Review of County Council's Response to Consultation

Planning Application No. 17/02534/OUT-2

**Land North of Bicester Avenue, Garden Centre, Oxford Road,
Bicester**

Cherwell District Council

— Highway Boundary

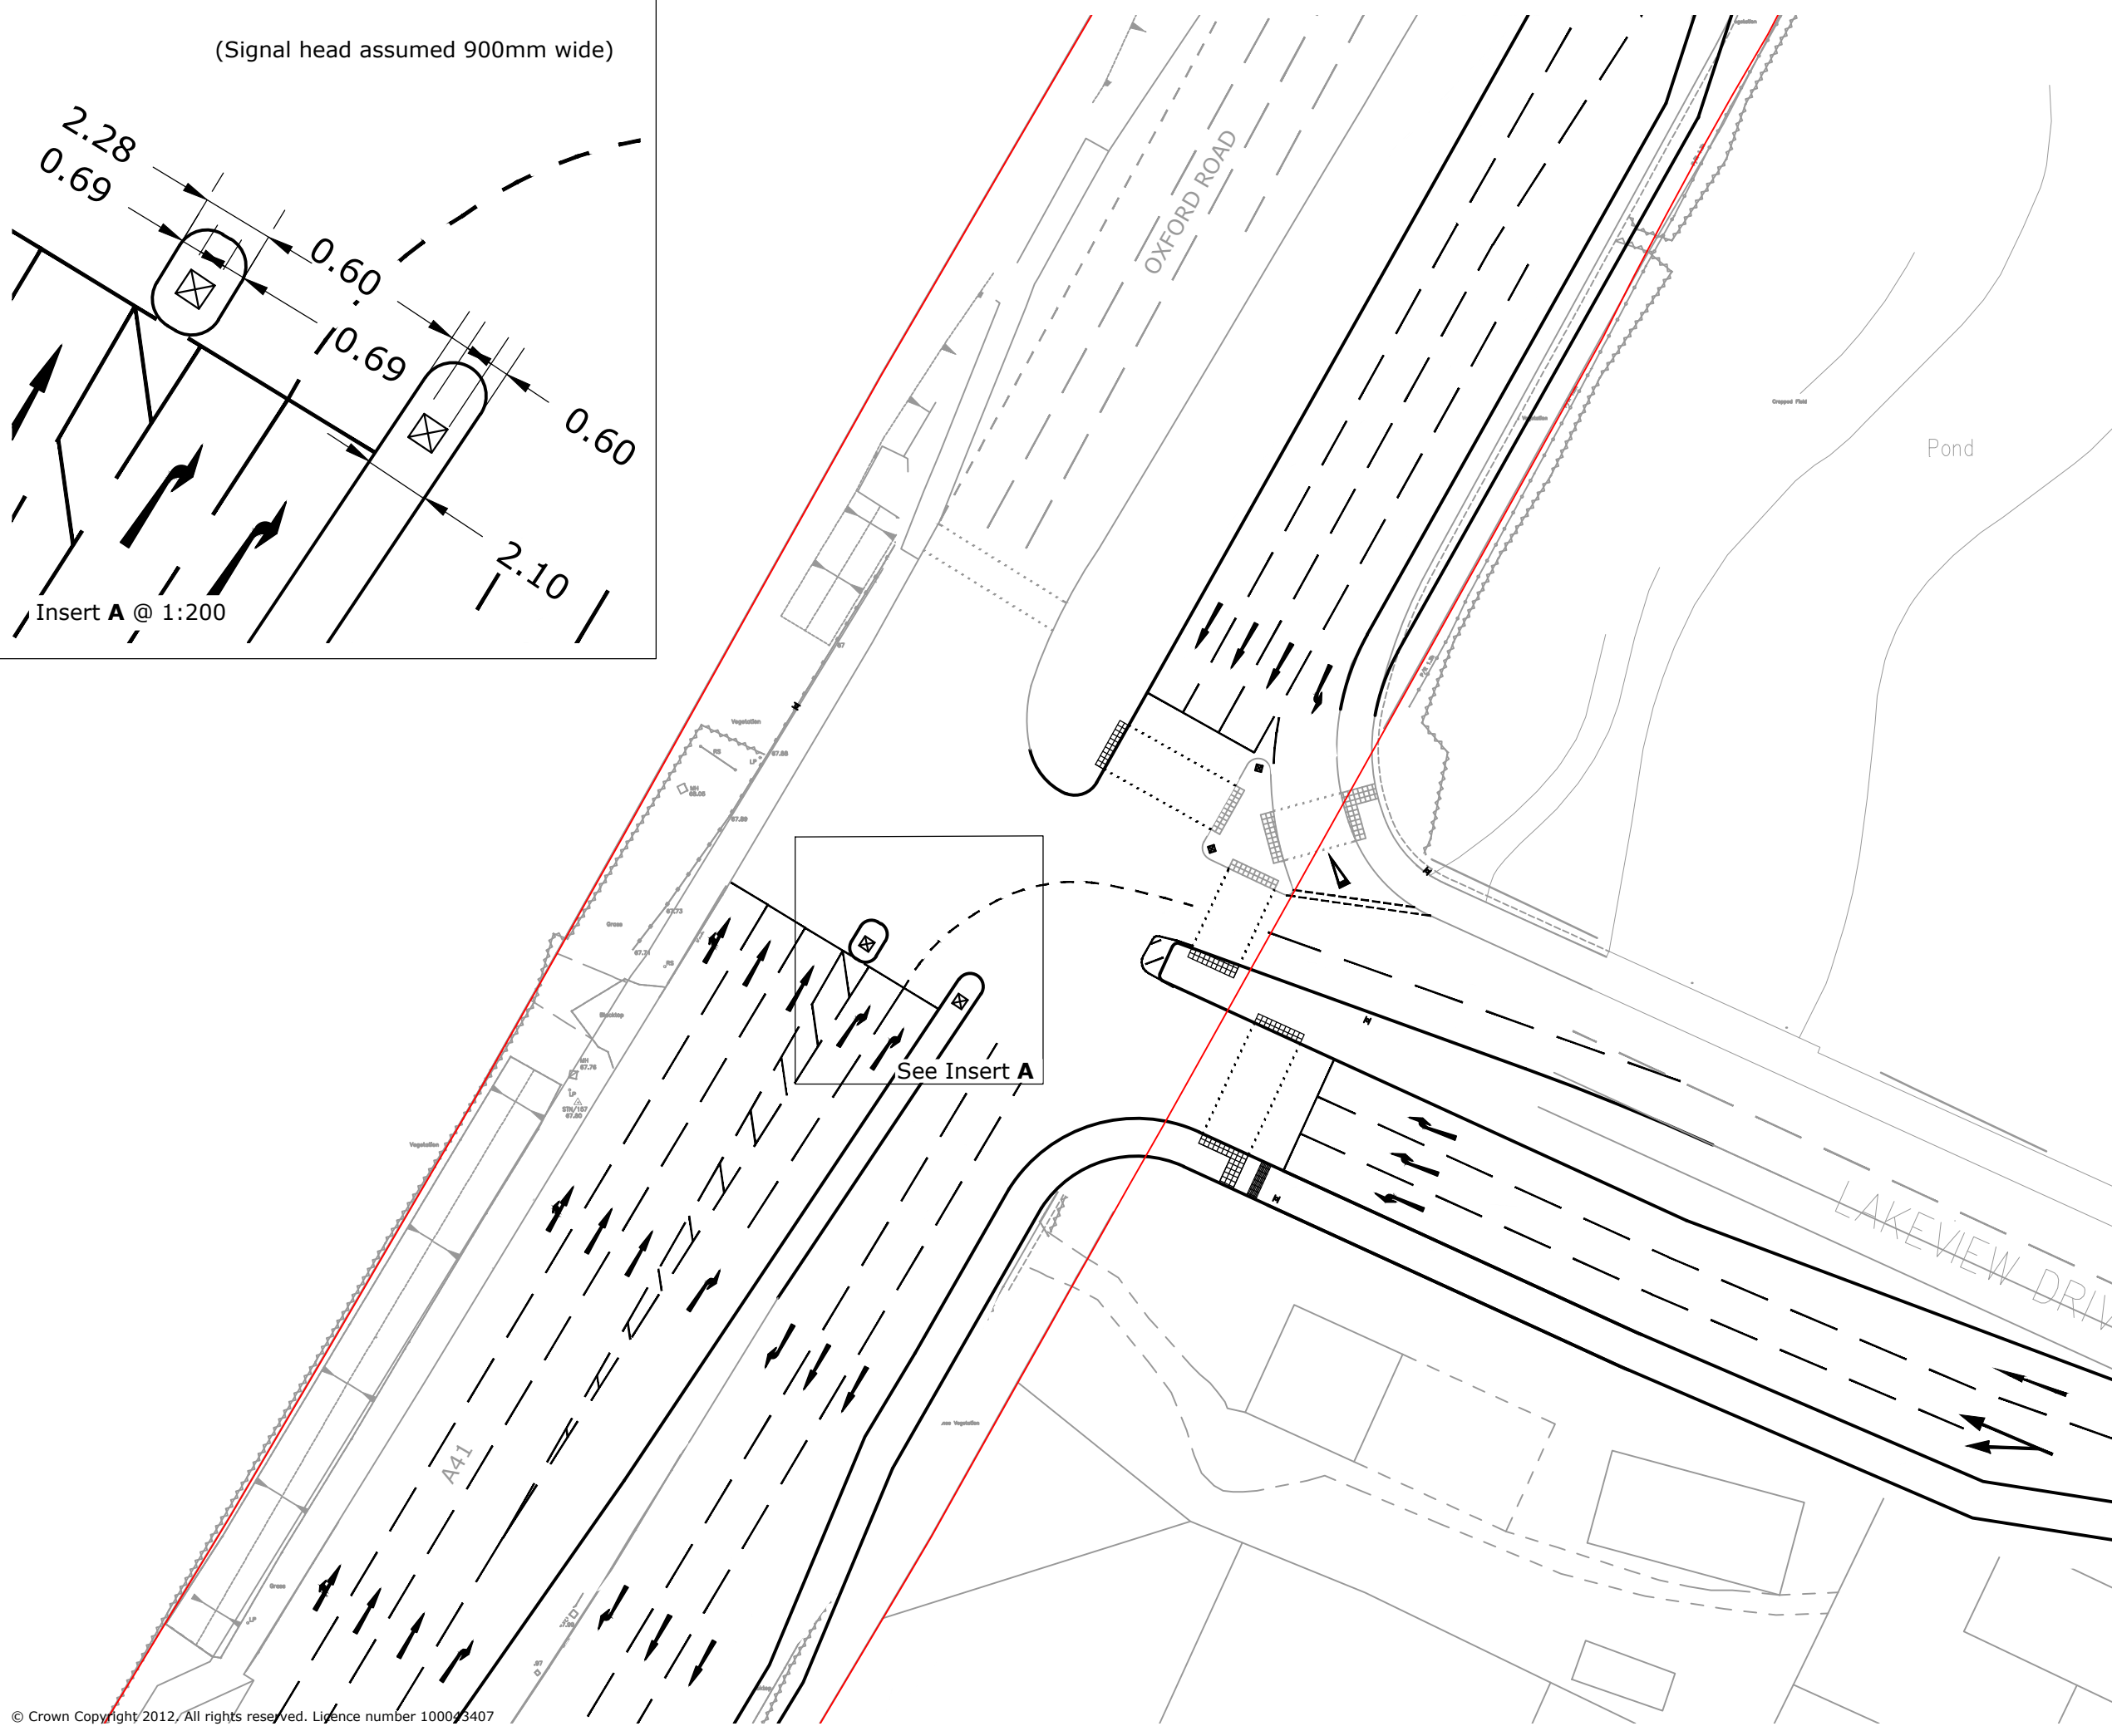
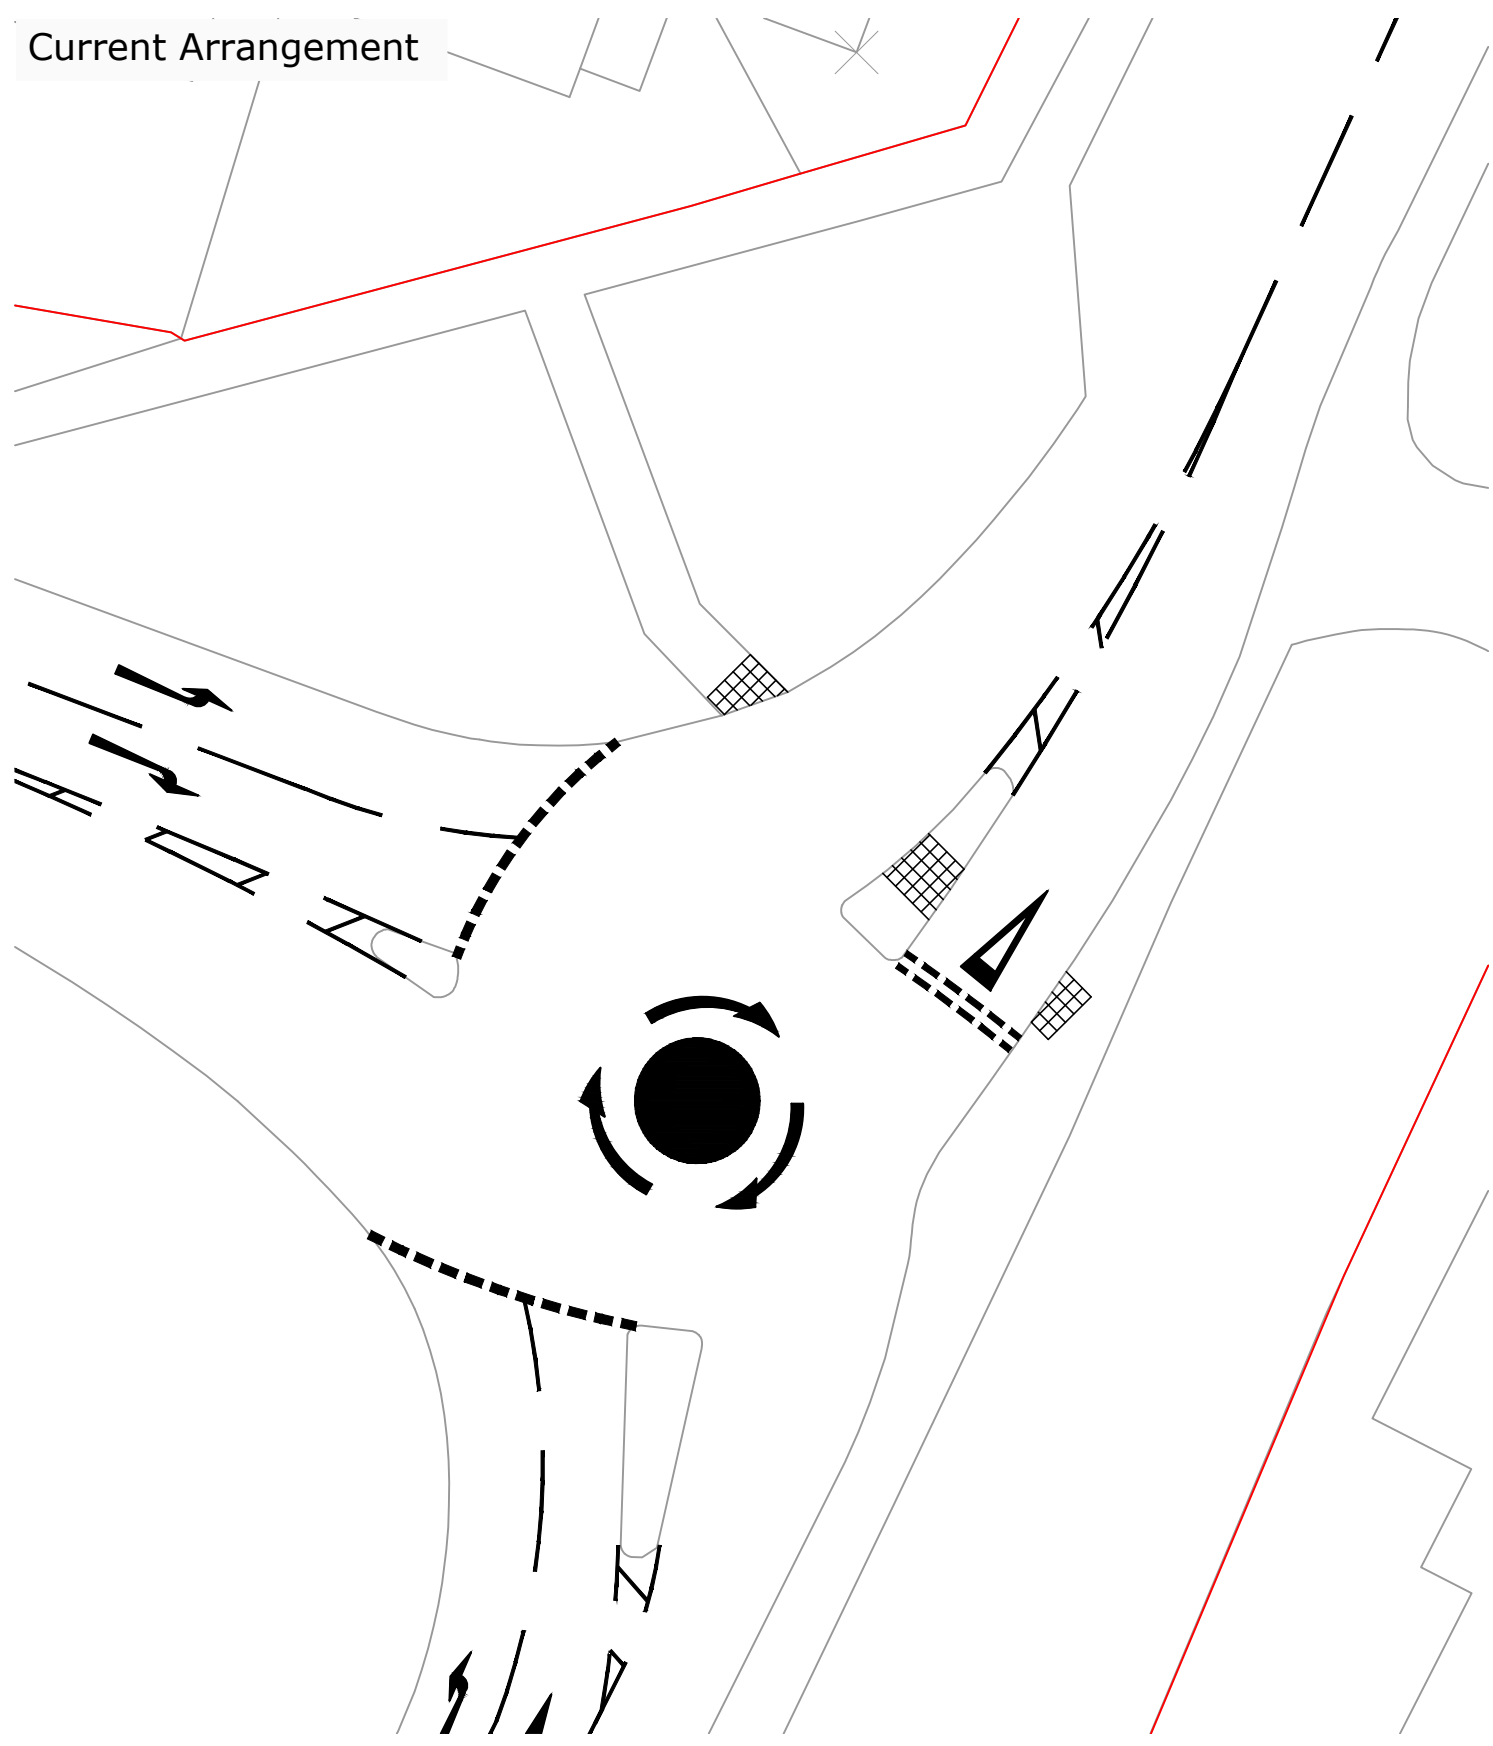
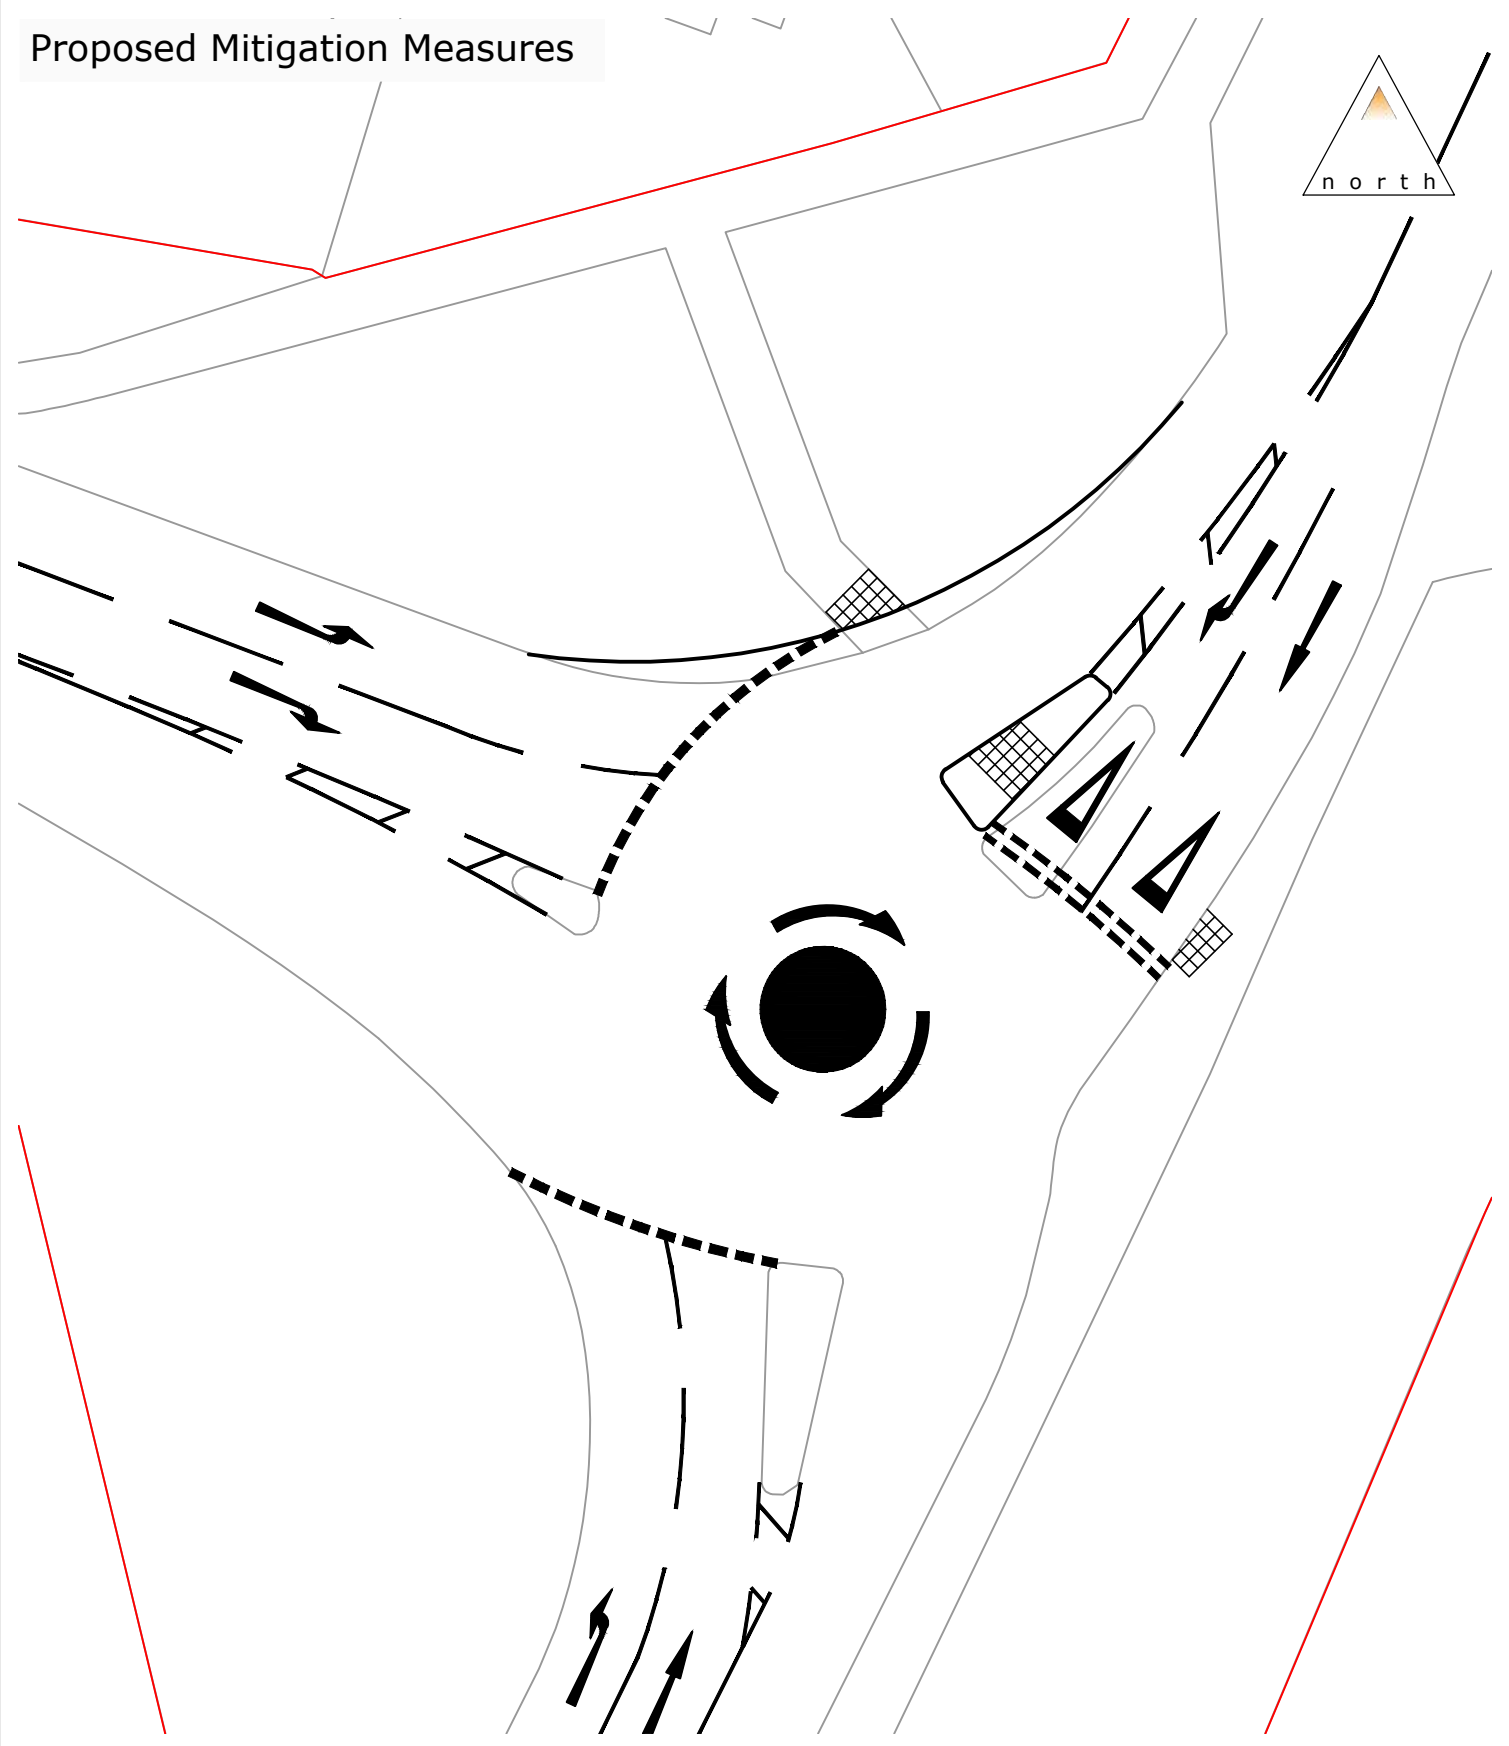
- 3.11 OCC believe the proposed development would have a detrimental impact on the existing network which has not been adequately mitigated. OCC are concerned that even with the proposed mitigation the analysis shows queues on Lakeview Drive reaching 42 vehicles. OCC consider that the storage capacity between the junction and the Tesco roundabout is approximately 15 vehicles which would effectively result in traffic adversely affecting the performance of the Tesco roundabout junction and the ability of traffic being able to egress the Tesco car park. OCC also contend that if vehicles are unable to exit Tesco 'it is likely that traffic within the site would back up to the extent that vehicles would not be able to get in, with the risk that queueing traffic would back up onto the A41'.

- 3.12 OCC also consider that on Lakeview Drive '... Very substantial delays could also be detrimental to road safety as they may well lead to unsafe manoeuvres by impatient drivers.'

- 3.13 In considering OCC's concerns I would suggest that its worth bearing in mind:
- a. The LinSig analysis is for the AM and PM peak hours only;
 - b. The base scenario (see Table 1 above) already produces a queue of 21 on Lakeview Drive which is more than the 15 referred to by OCC so the matter of blocking the Tesco roundabout will already be an issue during the PM peak hour.

- c. The LinSlig analysis does not take account of the benefits of MOVA
 - d. The access drive serving the Tesco car park has a very long two-way drive so even if there was a queue during the PM within the car park waiting to egress I doubt whether this would adversely affect the ability of drivers being able to access the car parking spaces.

- b) Notwithstanding a) above, that LinSig analysis reveals that the DoS deteriorates with three lanes exceeding 90%. This is likely to mean that these lanes will be sensitive to future increases in traffic or variations in traffic volume leading to disproportional increases in queues and delays. This is a matter, I'll return to on the section entitled 'Planning Obligations'.

- c) Whilst respecting OCC's concern about the impact on Lakeview Drive I am of the view that Lakeview Drive is a private road and as such unless the operation of the private road affects the public highway this is not necessarily a matter for the highway authority.

- d) I refer to OCC's concern about substantial delays on Lakeview Drive being detrimental to road safety due to the possibility this may lead to unsafe manoeuvres by impatient drivers. With respect to OCC, I regard this as unsubstantiated speculation unless there is reasonable evidence available that can be used to support this assertion.

- e) As alluded to in 3.9(d) above the access drive serving the Tesco car park is two-way and provides plenty of internal storage capacity so, from the information provided, I find it difficult to share OCC's concern that traffic within the site would back up to the extent that vehicles would not be able to get in, with the risk that queueing traffic would back up onto the A41.

3.15 In summary and bearing in mind that the Stage 1 Road Safety Audit raises no objections to the design, in principle, I consider the proposed mitigation to be acceptable subject to:

- a) S106 obligations being agreed (see below);
- b) The LinSig models being updated (see para. 3.3) to validate my views about the proposed mitigation being acceptable.
